# Action for Public Transport (N.S.W.) Inc.

## **CBD and SOUTH EAST LIGHT RAIL**

### **MODIFICATION ASSESSMENT REPORT SSI 6042 MOD 1**

Figure 3.4 Plan of the modified Moore Park stop arrangement

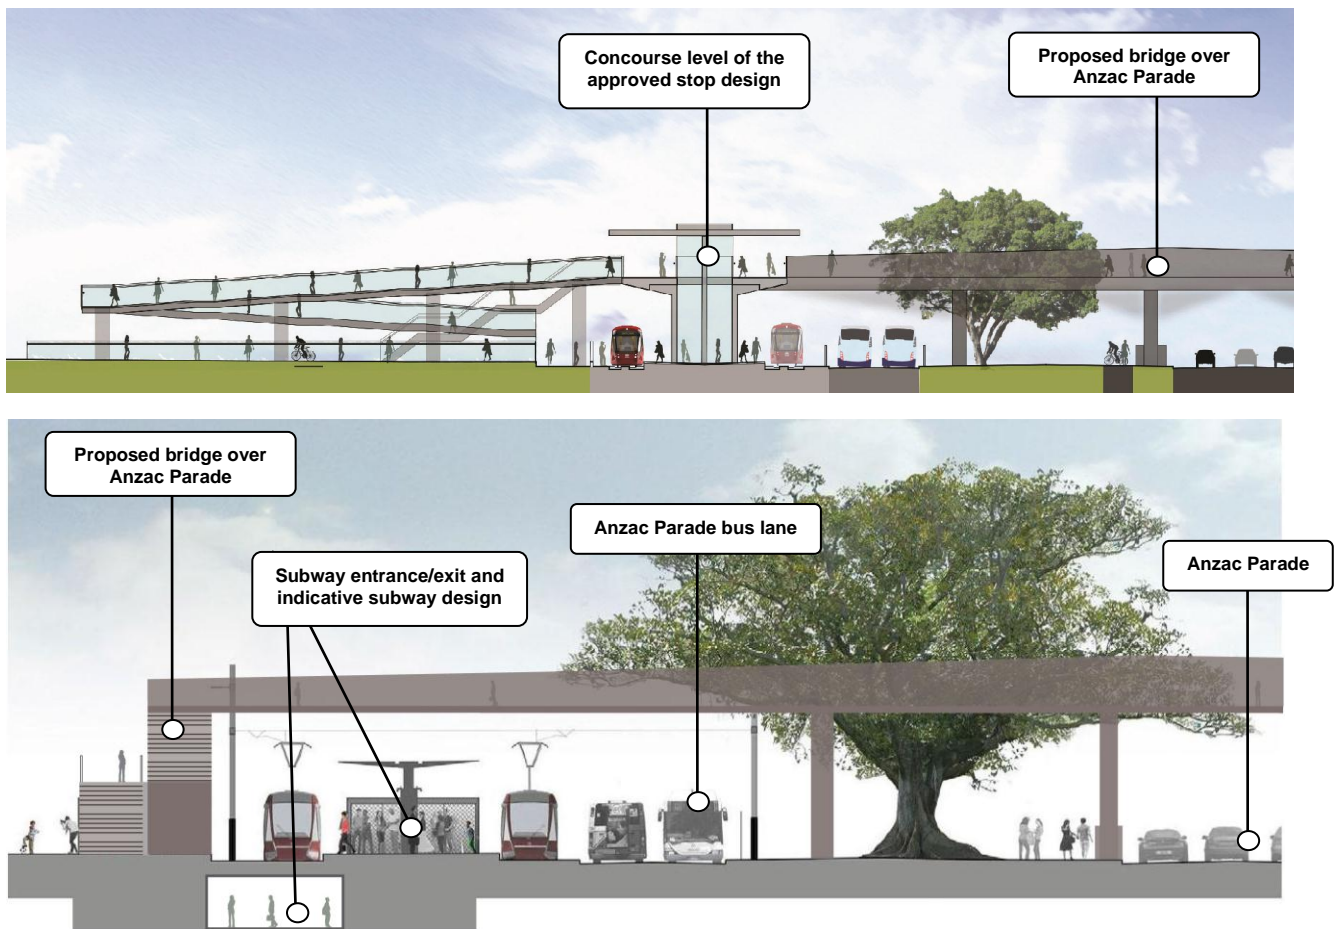
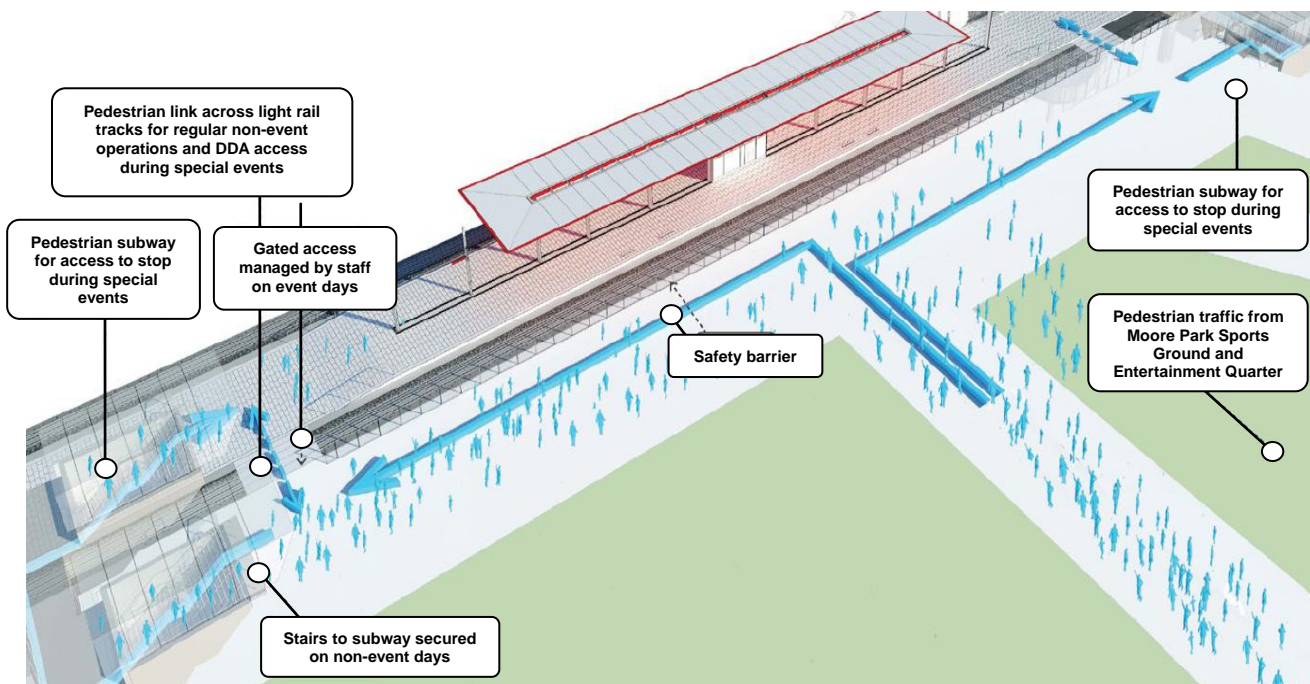
- a. We note the proposal to provide pedestrian underpasses at the Moore Park Stop. There appears to have been a change of heart regarding pedestrian tunnels at Transport for NSW (TfNSW) – a pedestrian underpass had been proposed as an alternative to the excessively expensive and intrusive “Tibby” Cotter Bridge currently being constructed over Anzac Parade in Moore Park, just 250 metres from the stop site. The proposal for a pedestrian subway was rejected at that time, on questionable grounds.
- b. The proposed pedestrian bridge can be dispensed with.

Consideration should be given to abandoning the proposed pedestrian bridge in favour of a western extension, under Anzac Parade, of the proposed pedestrian underpass at the northern end of the stop. Such an underpass would eliminate much stair climbing by students at the High Schools, as the general level of the school campus lies some four metres below the level of Anzac Parade. The extended subway would provide students with near-level access to and from the stop for their twice-daily commute. There are public health implications. Casual observation would confirm that many of the early-teen students carry significant loads in their backpacks. Reduced stair-climbing would be to their distinct advantage. The perceived negative public safety aspects of pedestrian subways could be ameliorated as there is usually teacher surveillance of departing students at the end of the school day.

The visual aesthetics of the Moore Park vista would be improved without the bridge. The bridge was described in the CSELR Preferred Infrastructure Report (p 6-41) as having a “high adverse impact overall during operation”. It is known that this is a matter of concern to nearby residents and other supporters of Moore Park.

Figure 3.19 Revised Alison Road alignment and relocated Royal Randwick Racecourse stop

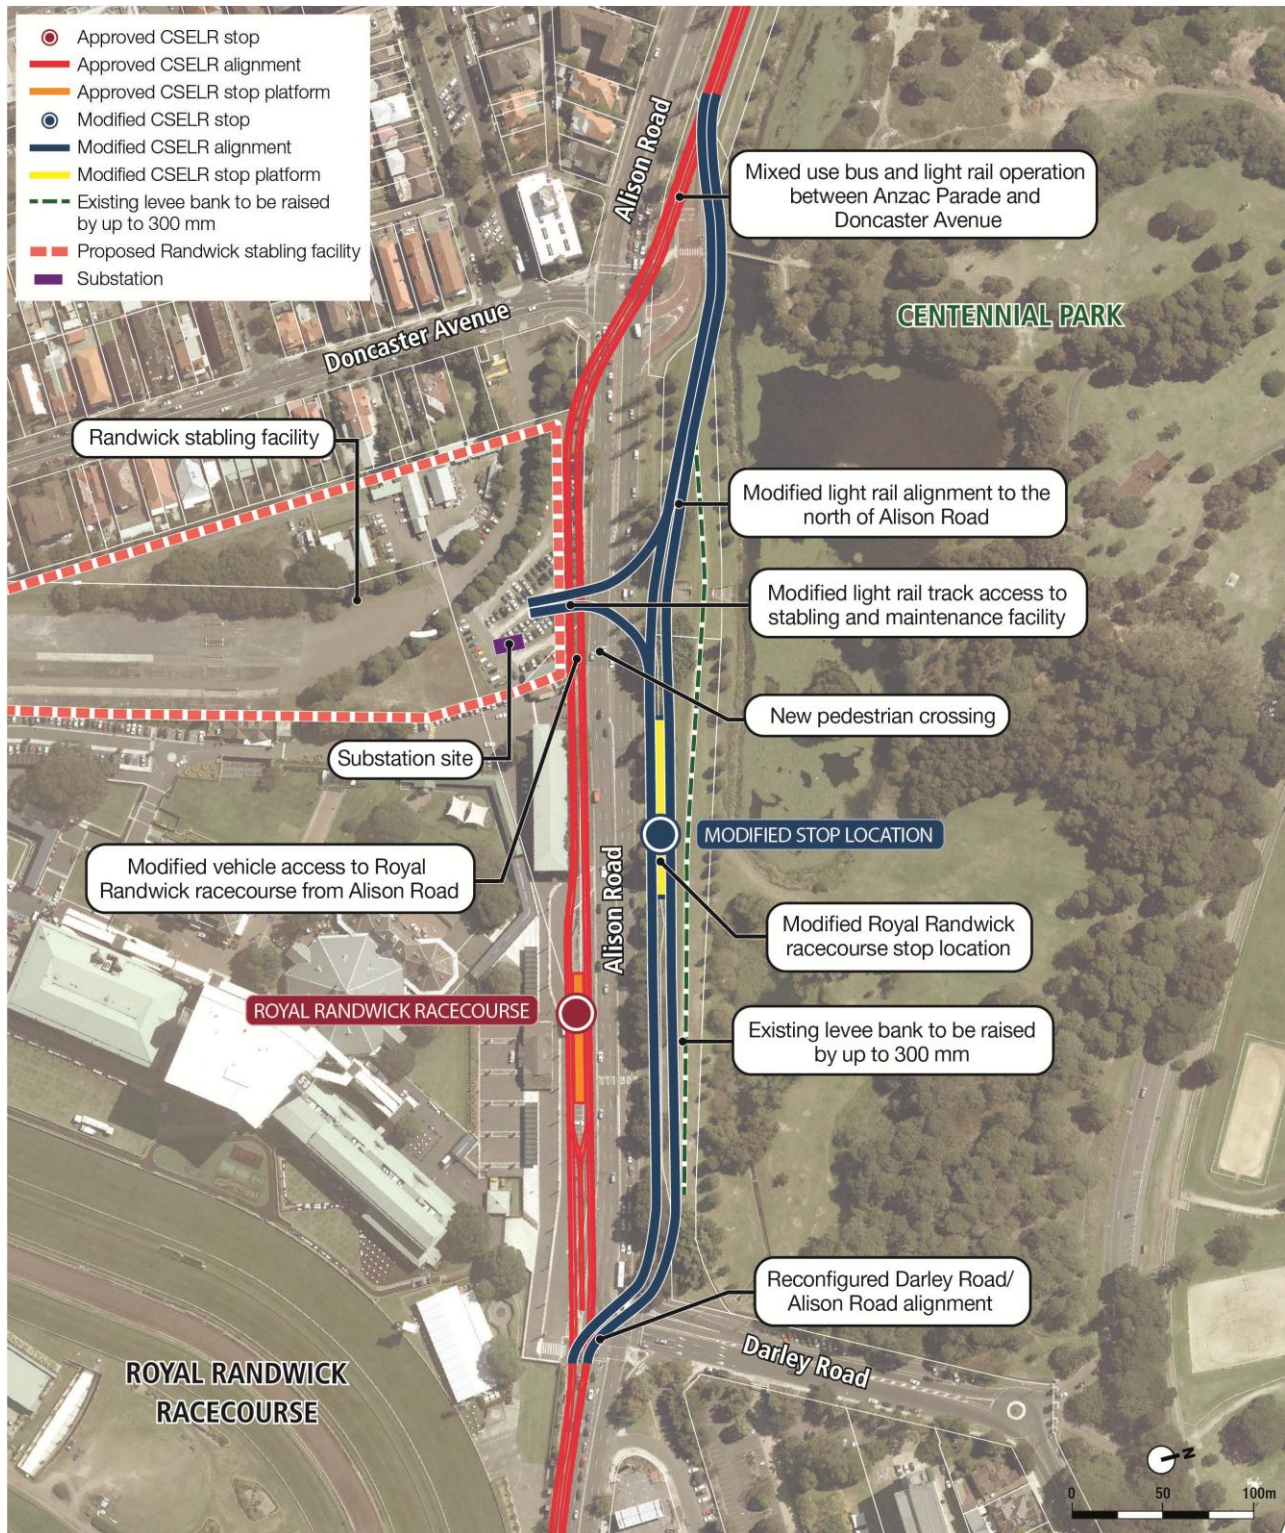
We are surprised that the preferred site for the racecourse stop has been moved to the north side of Alison Road. Given the potential for conflict between “event” crowds and road traffic on Alison Road, we would have thought a modification to the tracks entering the LRV storage facility, with a platform giving direct access to the racecourse grounds would have been fully justified, as it would provide valuable operational and pedestrian-safety benefits. There would be additional operational benefits in extending a track to the Kensington main line (via Ascot Street), thus avoiding the need for LRVs to change direction at the platform. It would also have separated “event” (racecourse) tram operations from normal service operations. We are forced to conclude that the design team has abandoned any serious effort to maximise the attractiveness of dedicated light rail services to the racecourse. This must have a negative impact on road traffic congestion in the vicinity on “race” days.

Should the modified site be adopted as planned, then the stop itself should be moved eastward, closer to Darley Road, for the benefit of every-day TAFE students and other tram patrons. It appears that this can be done while still retaining a turnback road for a 67m tram.

Figure 3.25 Example of a 'third rail' track power arrangement (Bordeaux)

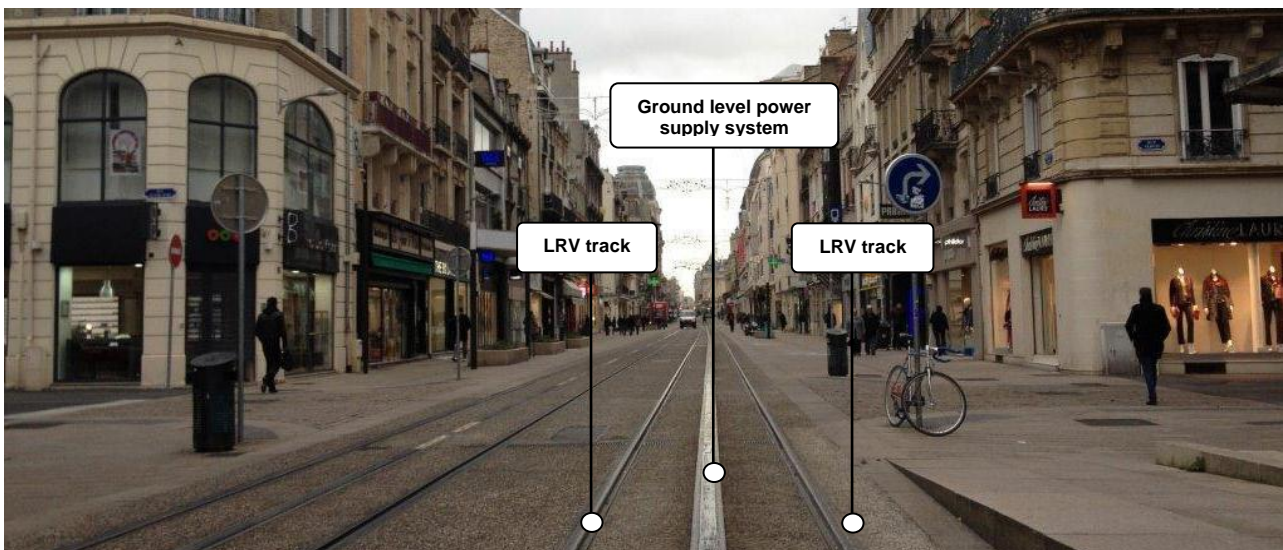
We note the intention to use Alstom's “Aesthetic Power Solution” (APS) continuous third-rail power supply to the LRVs at the north end of the Sydney CBD. The justification for this appears to us to be narrowly selective, over-riding the significant negative aspects of this form of power supply. For the record, we have been informed that this form of power supply can cost up to approximately \$38 Million per twin-track kilometre, and that is just the capital cost. We also understand that being a proprietary product, APS spare parts and maintenance equipment may only ever be available from a single supplier. This could incur significant cost penalties in the long term.

We request that the cost implications of this modification be thoroughly analysed by the Minister for Planning. In our view the modification should be rejected. Overhead wire should be used throughout.
